**Consultation Response from KC,
Highways Development Management**

2025/90372 Land at, Edgerton Road, Edgerton, Huddersfield, HD3 3AA

Discharge of details reserved by conditions 6, 7, 8, 9 (drainage), 11 (lighting scheme), 14 (Arboricultural Method Statement), 19 (Construction Method Statement), 21 (estate road), 22 (highway works), 23 (boundary treatments) on previous permission 2017/91916 for variation condition 23 (highway works) on previous permission 2014/93014 (APP/Z4718/W/15/3002523) for outline application for residential development comprising of 41 dwellings plus associated works (within a Conservation Area)

Client			
JONES HOMES (YORKSHIRE) LTD			
Project Title			
SECTION 38 CLAYTON FIELDS			
Drawing Title			
GENERAL ARRANGEMENT			
Scale	Drawing Size	Drawn By	Checked By
1:500	A1	TOD	TC
Project Number	Date	Approved By	
163366	January 25	DB	
Drawing Number	Rev		
163366-SAN-CLF-XX-DR-C-01_001	P02

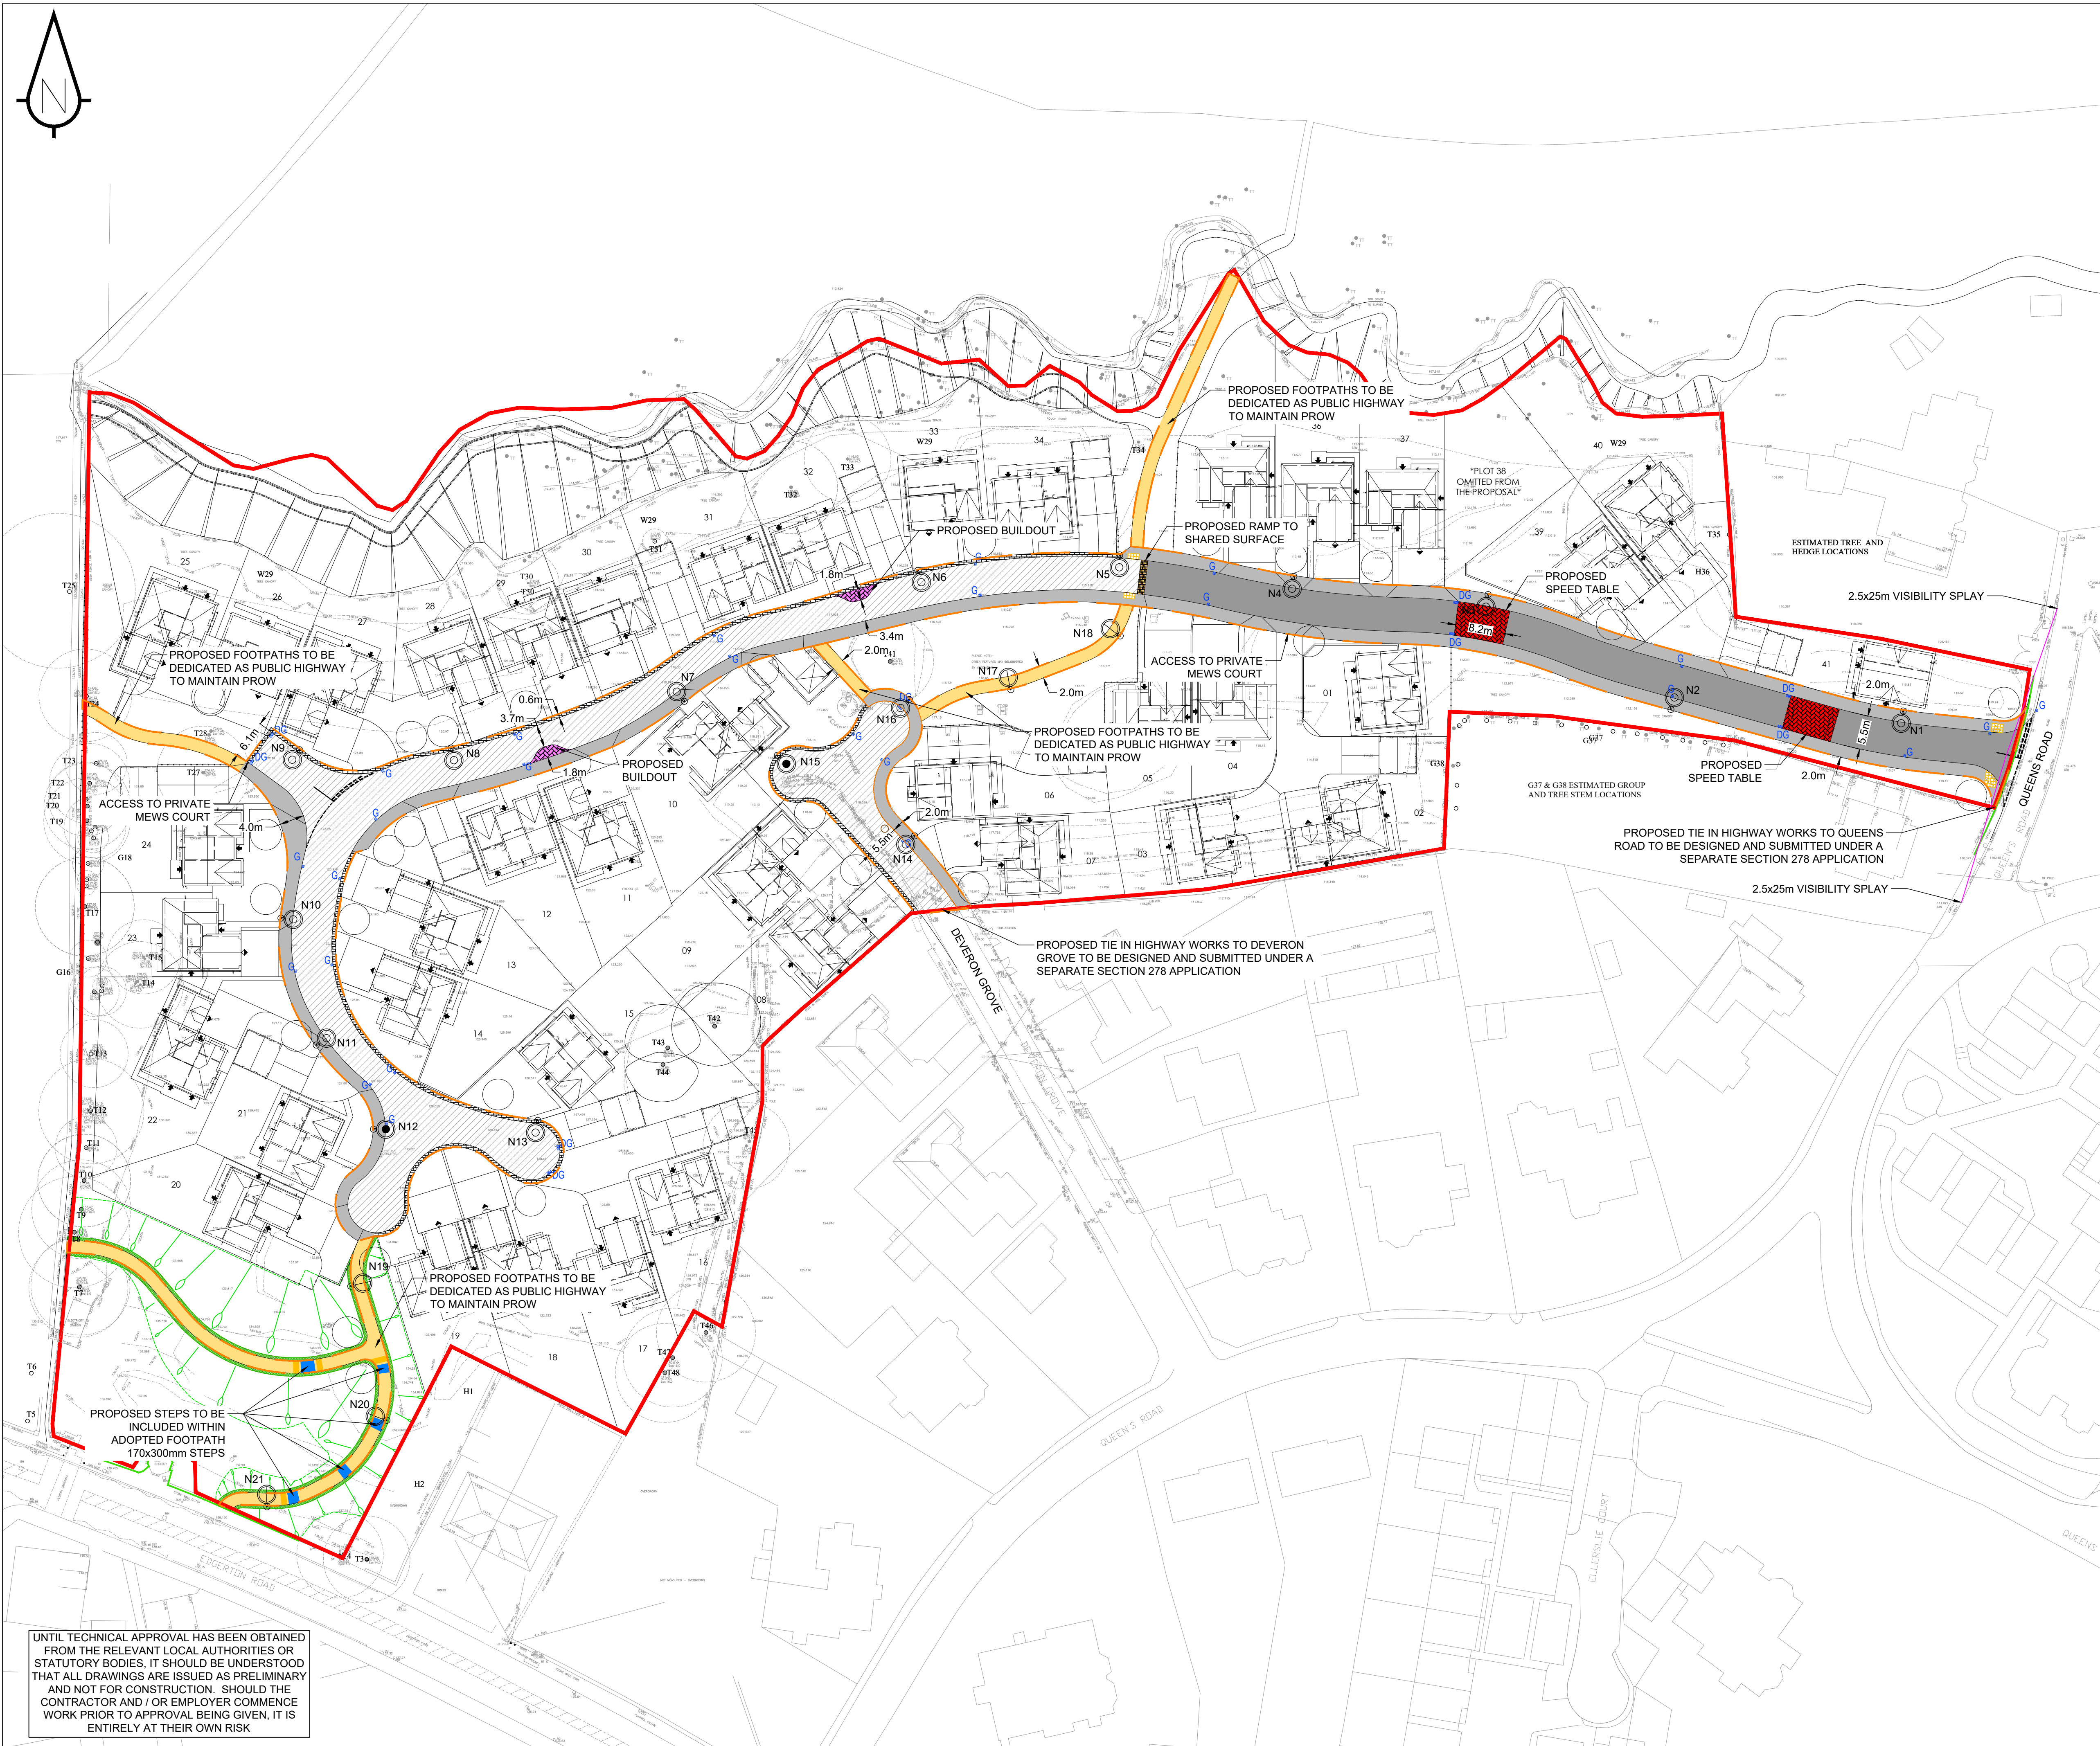
No Road Safety Audit or details of the required visibility splays are provided, and this condition should not therefore be discharged.
